1st February 2015

Re: Planning Application:

AW/353/14PL – 11 Marquis Way, Bognor Regis, PO21 4AT

project: 11 Marquis Way - Aldwick			
drawing title: Proposed Site Plan			
drawing status: Planning Application			
date: 09 - 12 - 2014	scale at relevant drawing size 1 : 50 (A1) or 1 : 100 (A3)	no: JW131105 - PL10	rev.: -

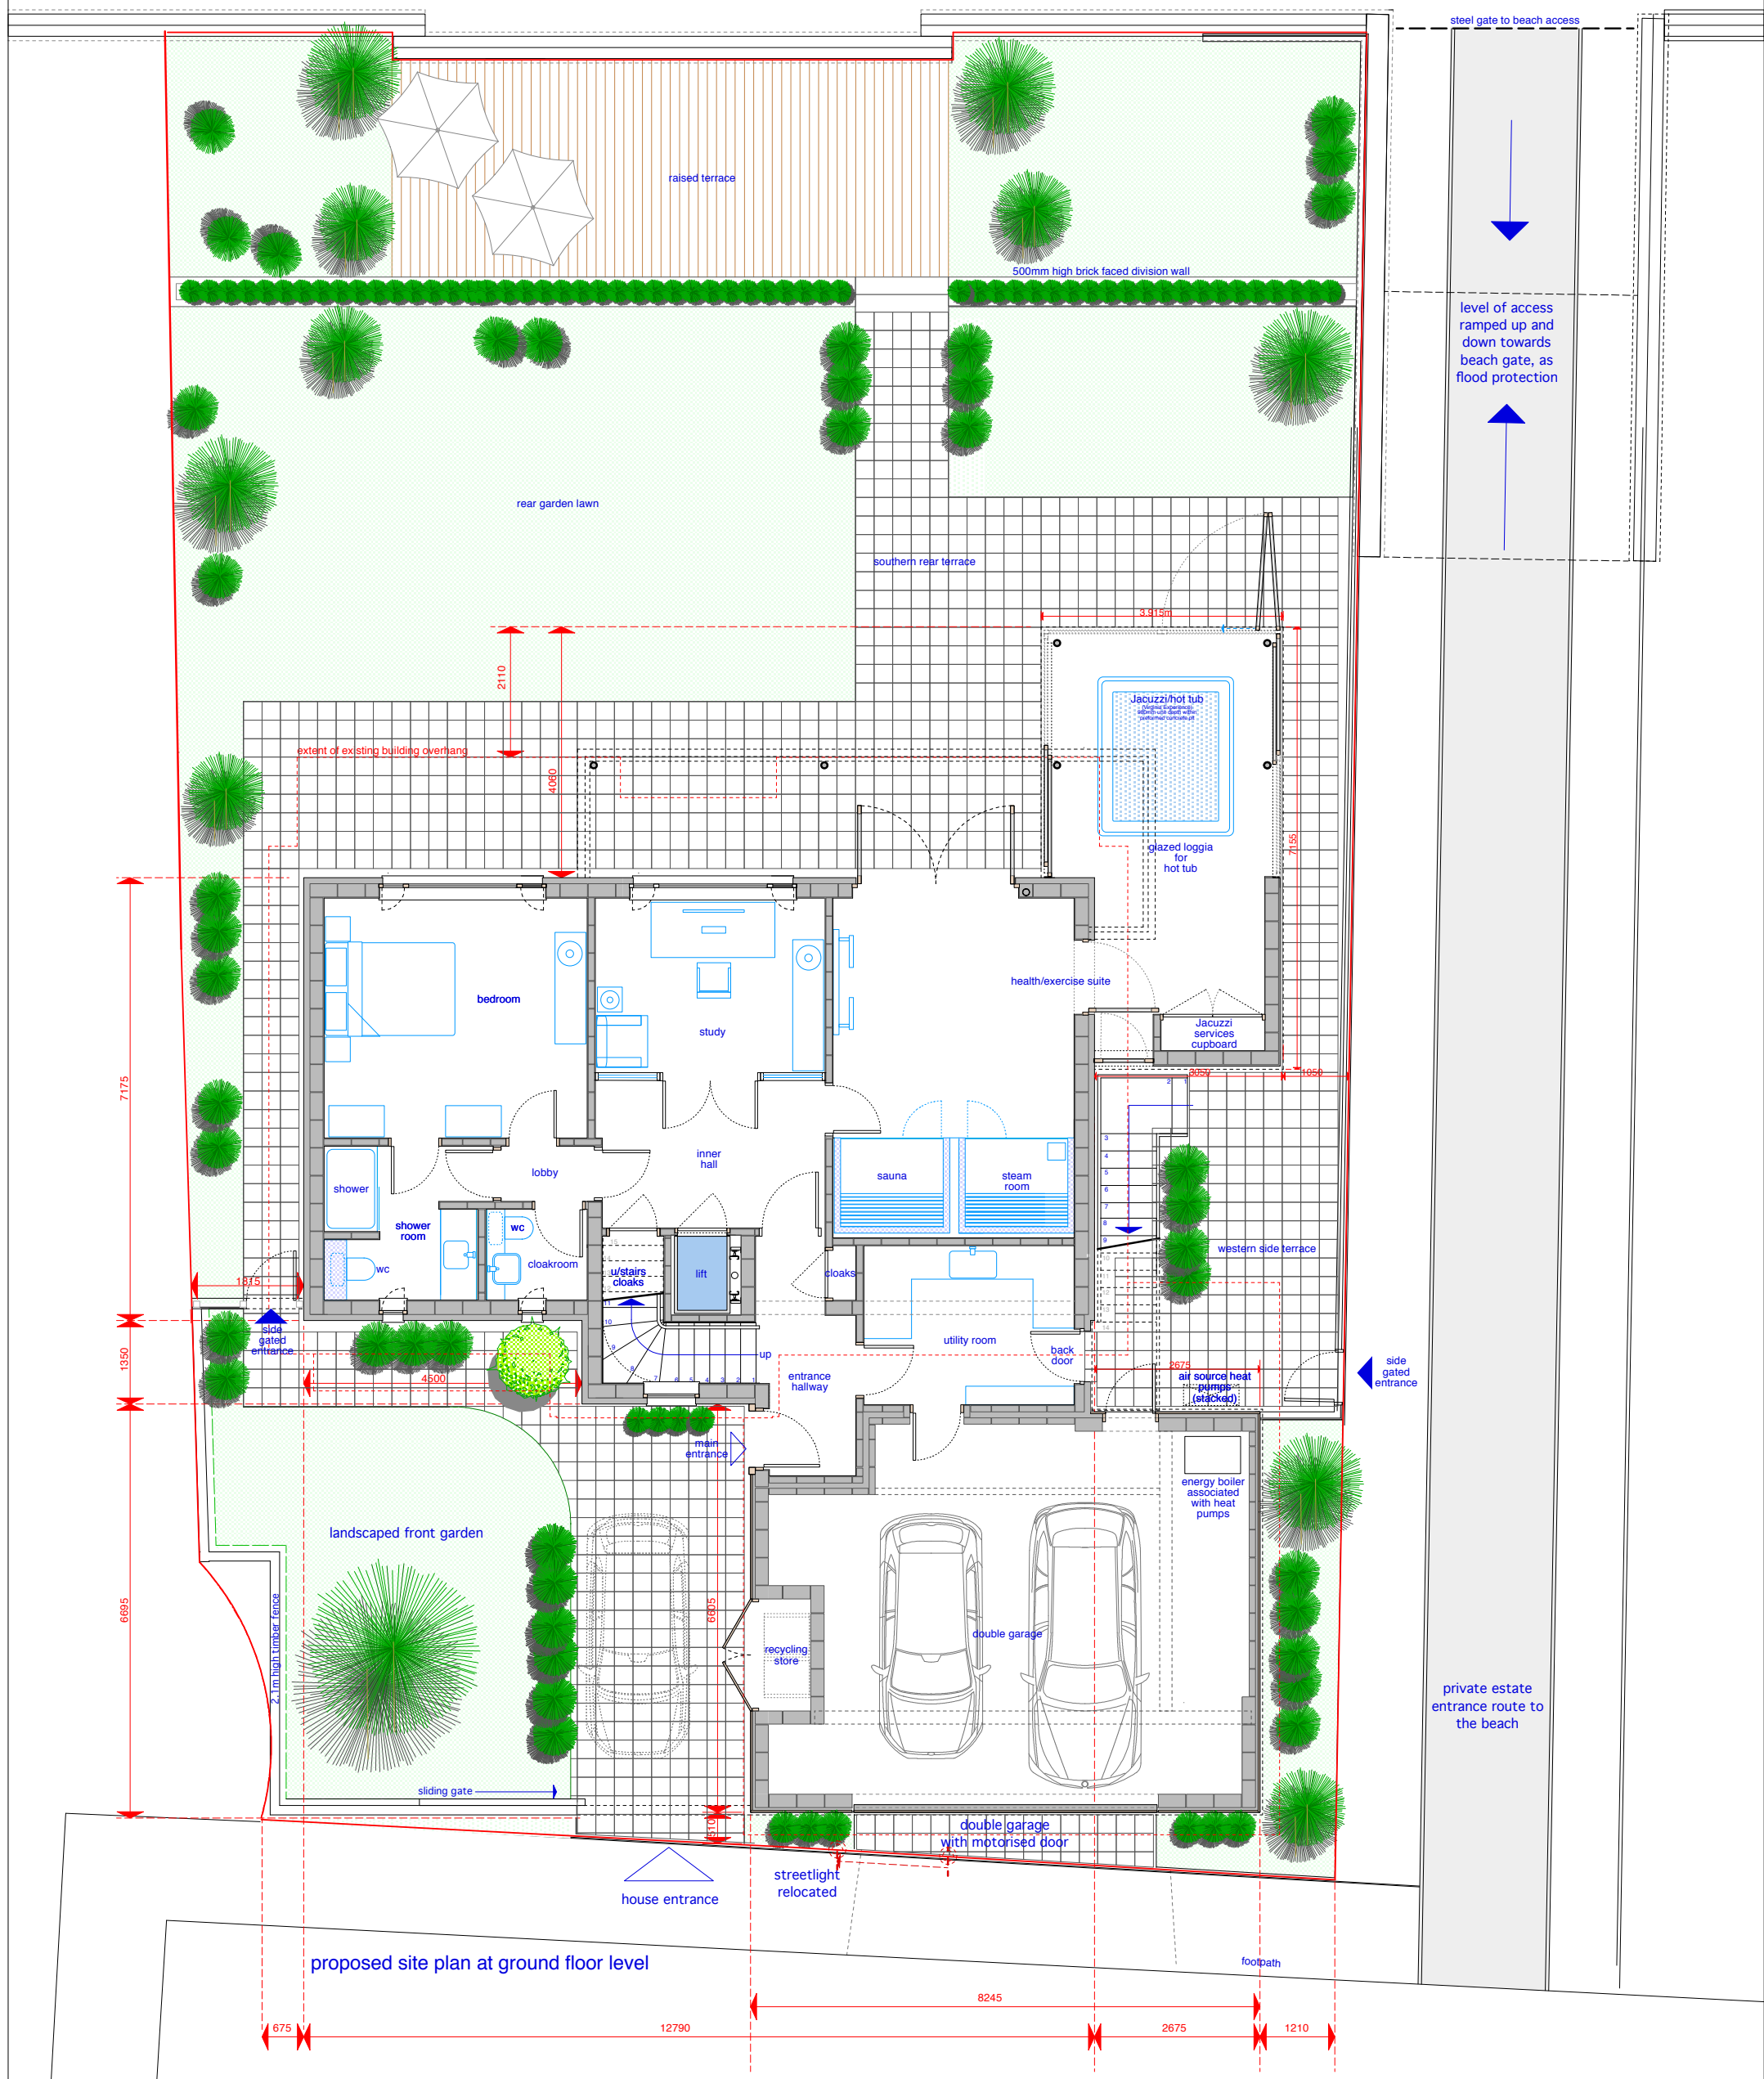
In addition to this, it is my understanding from having studied the proposals, that the new dwelling as planned, would extend beyond the current building line. This is a factor which has been enforced in the past when planning was approved for an extension at No. 15
